Gatwick Northern Runway

TR020005

National Highways Comments on any Submissions Received by Deadline 2

April 2024

### Defra Metric – Area Impacted

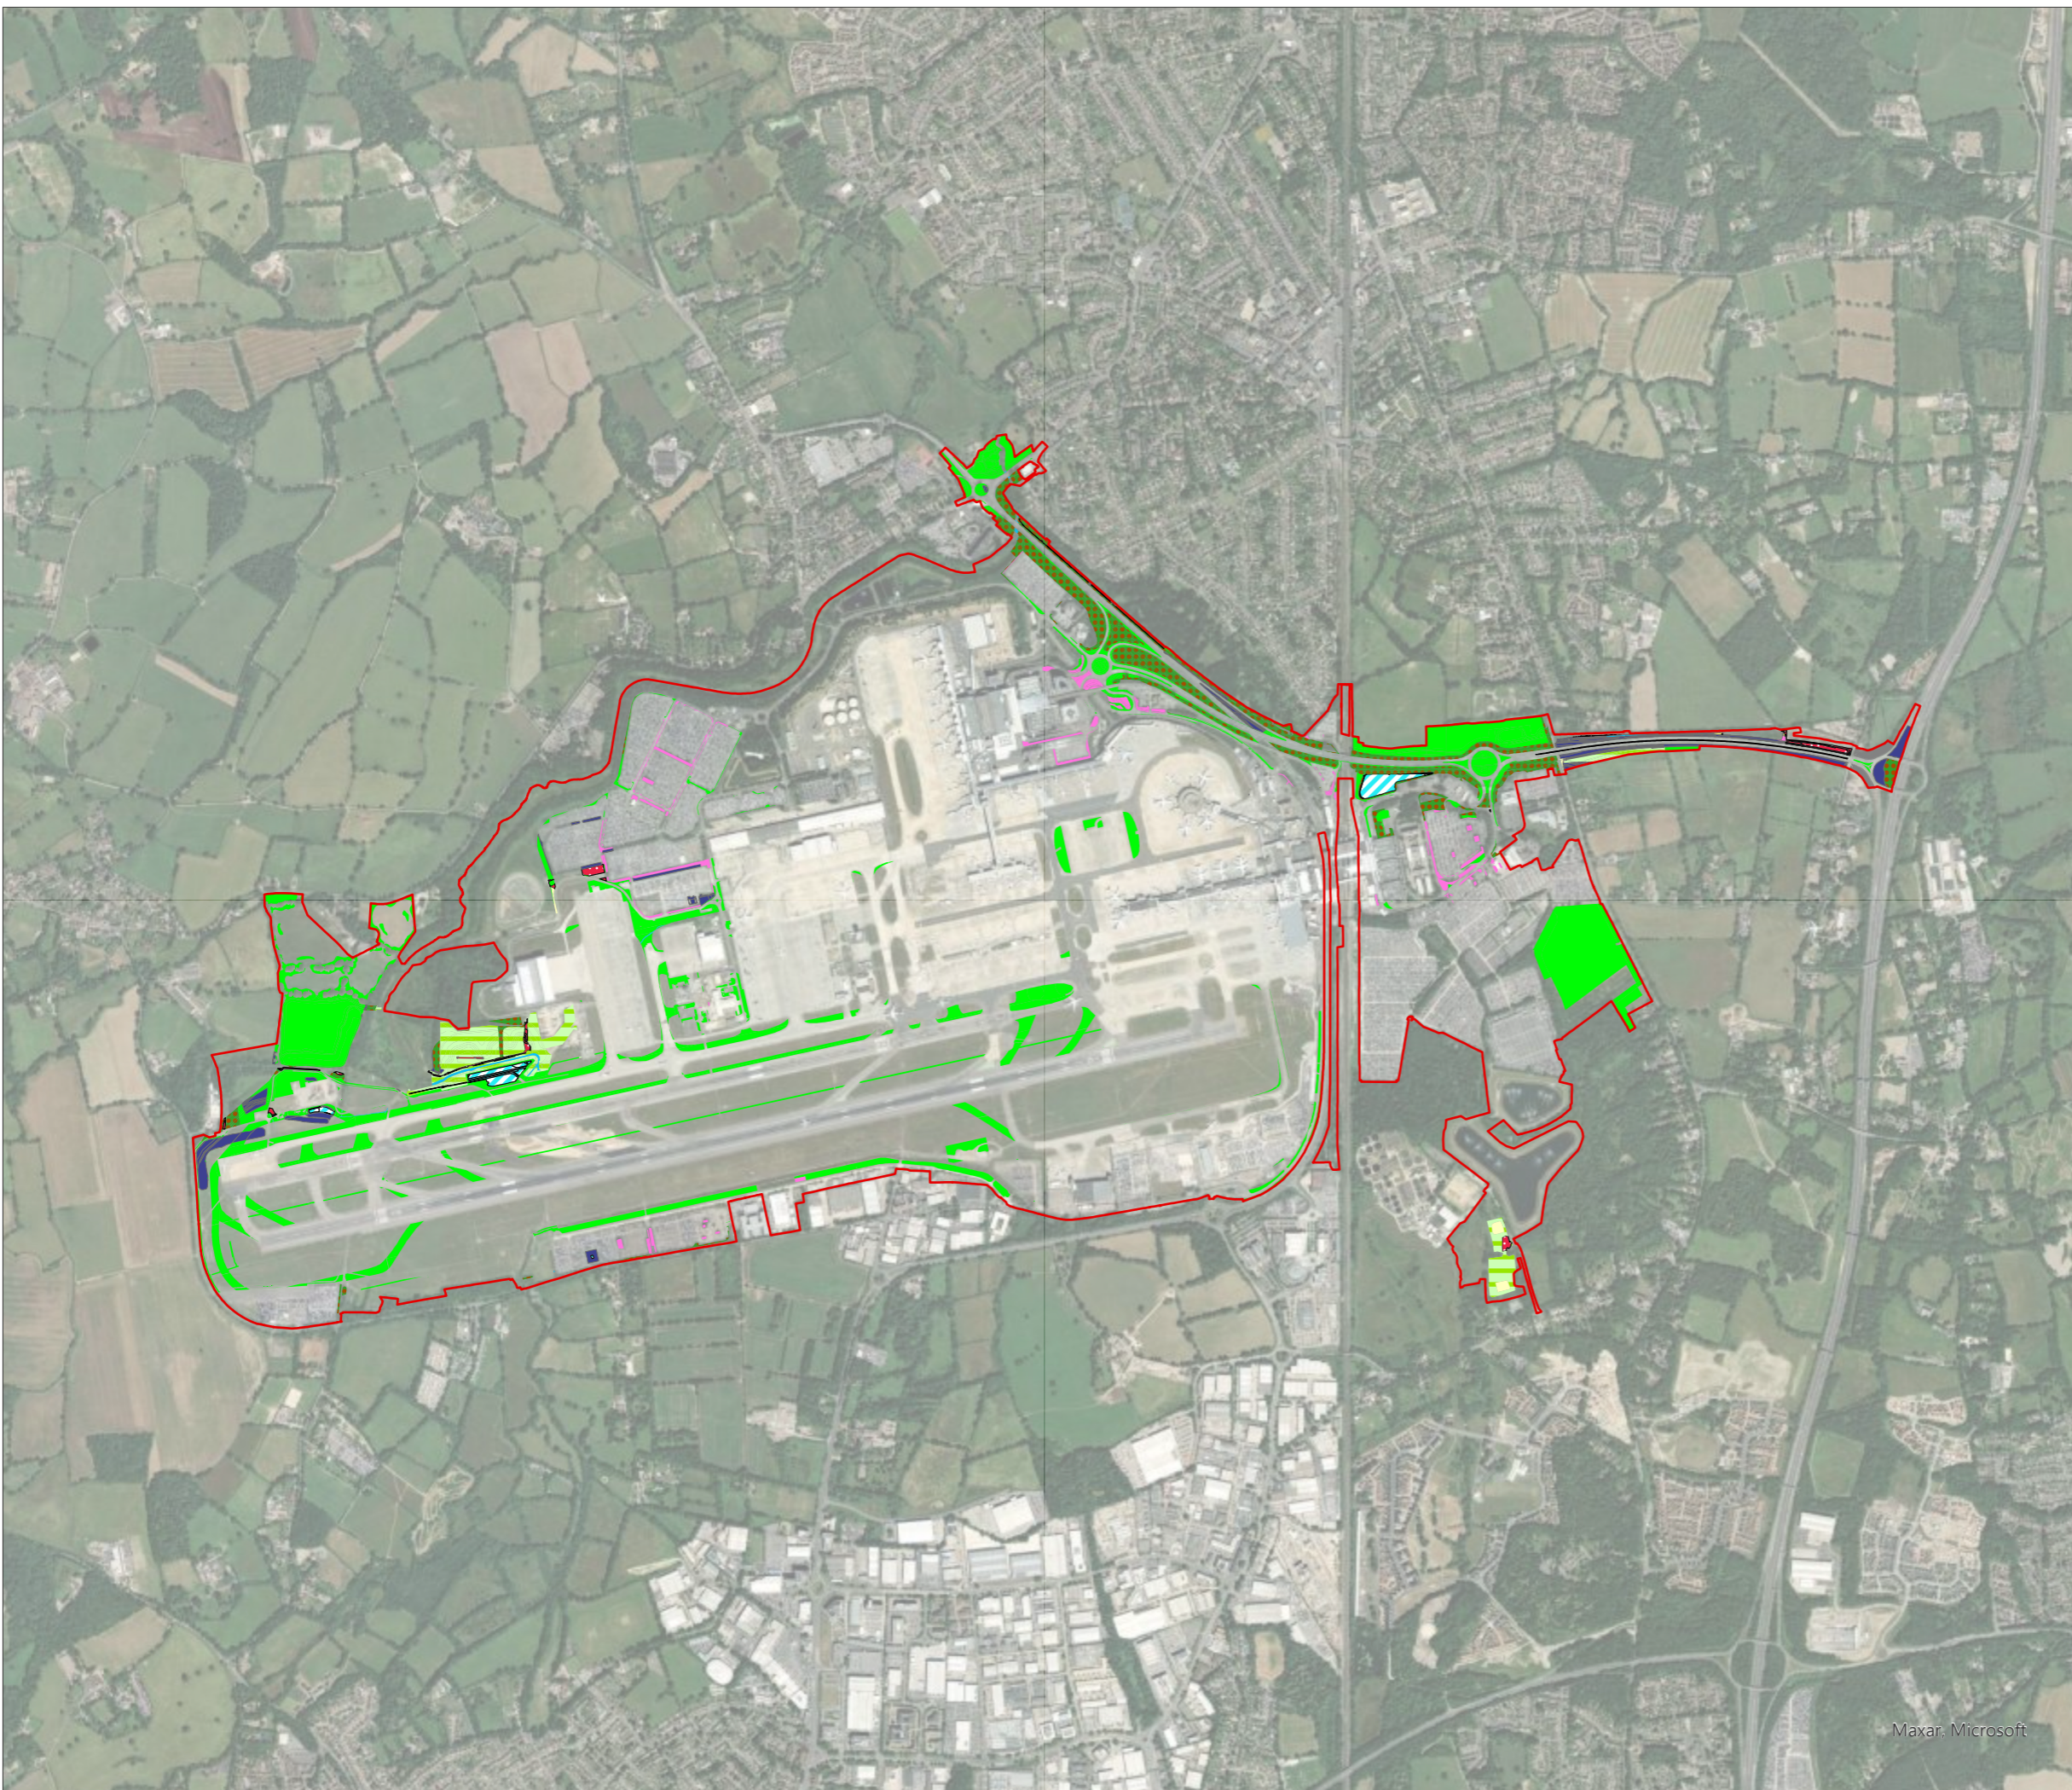
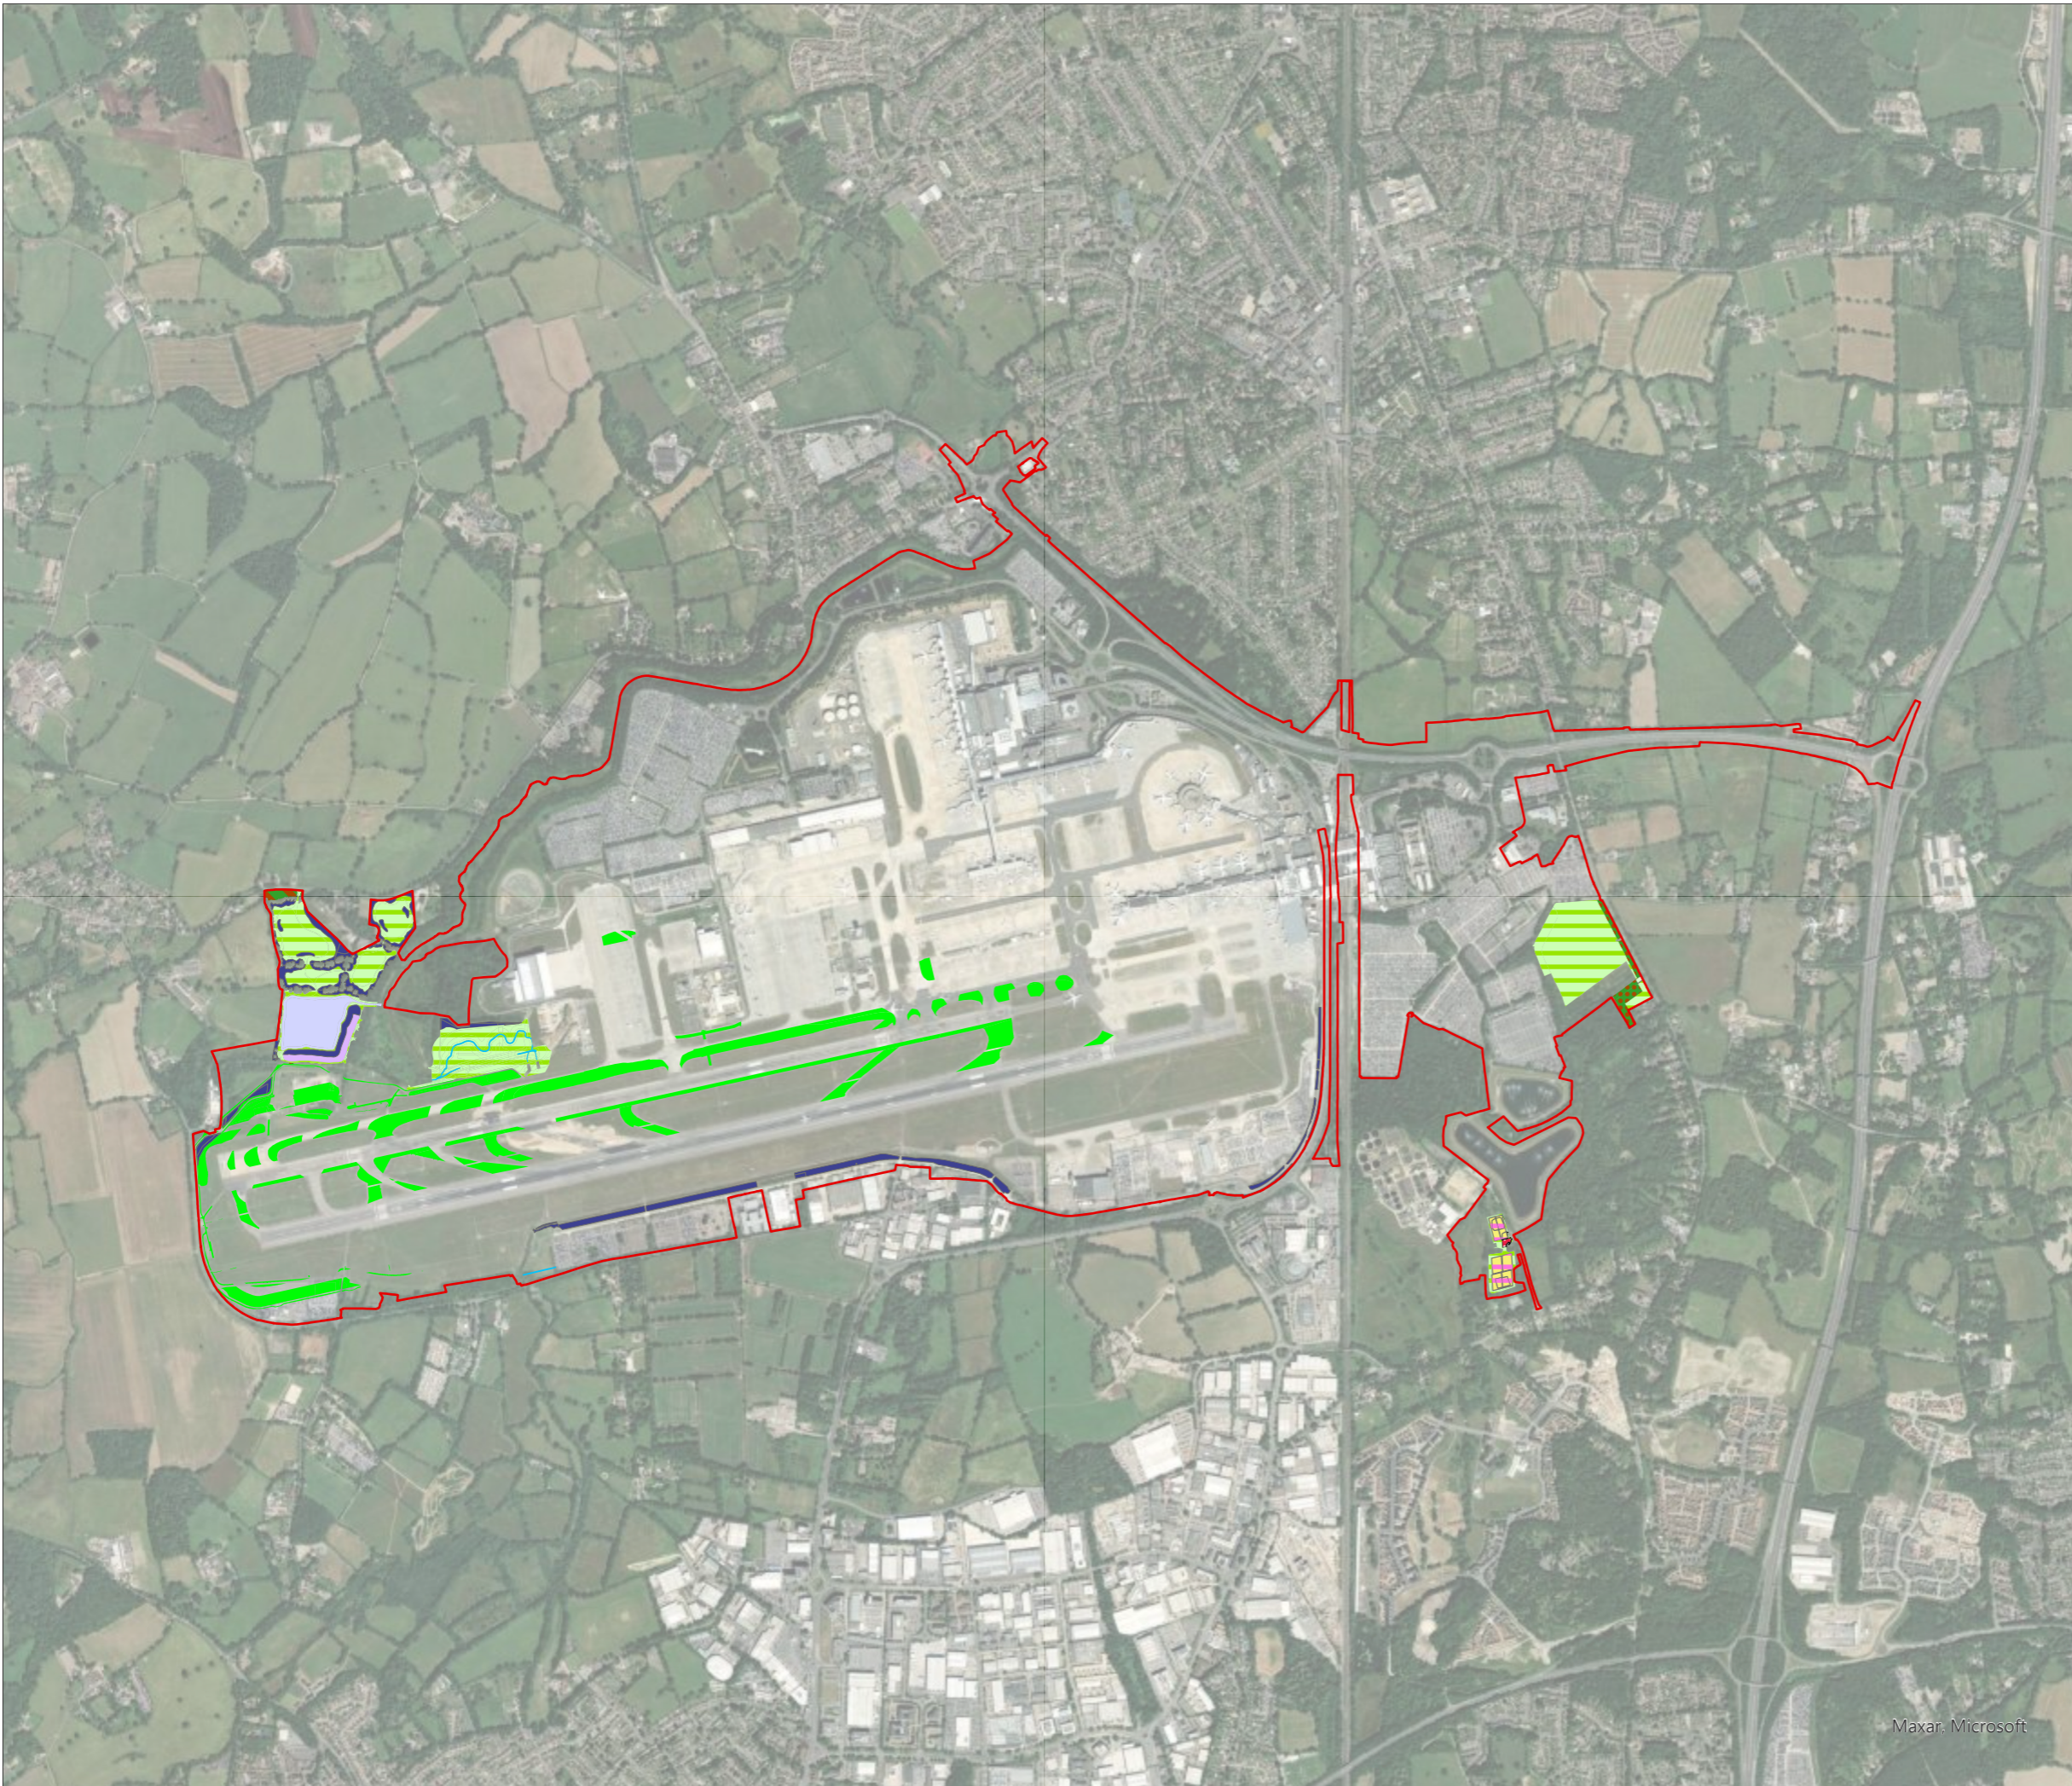
5.3 Environmental Statement Appendix 9.9.2: Biodiversity Net Gain Statement (Tracked) – Version 2			
Section 3.1.2 and Table 3.2.1	REP2-029	<p>The description below (Table 3.2.1) relates to each row in the baseline of the Defra Metric 4.0 for the areas impacted (Annex 1).</p> <p>The total area which would be impacted is 230.99 ha (Table 3.2.1).</p>	<p>National Highways requests that the Applicant confirms whether Table 2.5.1 on page 2 of the updated Biodiversity Net Gain Statement should instead read as Table 3.2.1 as referred to in Section 3.1.2.</p> <p>In addition, National Highways queries whether the total area which would be impacted noted in Section 3.1.3 remains as 230.99 ha given the areas that have been added as part of the updated document. It is further noted that Table 3.2.1 currently amounts to a total of 241.6 ha so National Highways requests clarification from the Applicant as to the true value of areas impacted.</p>
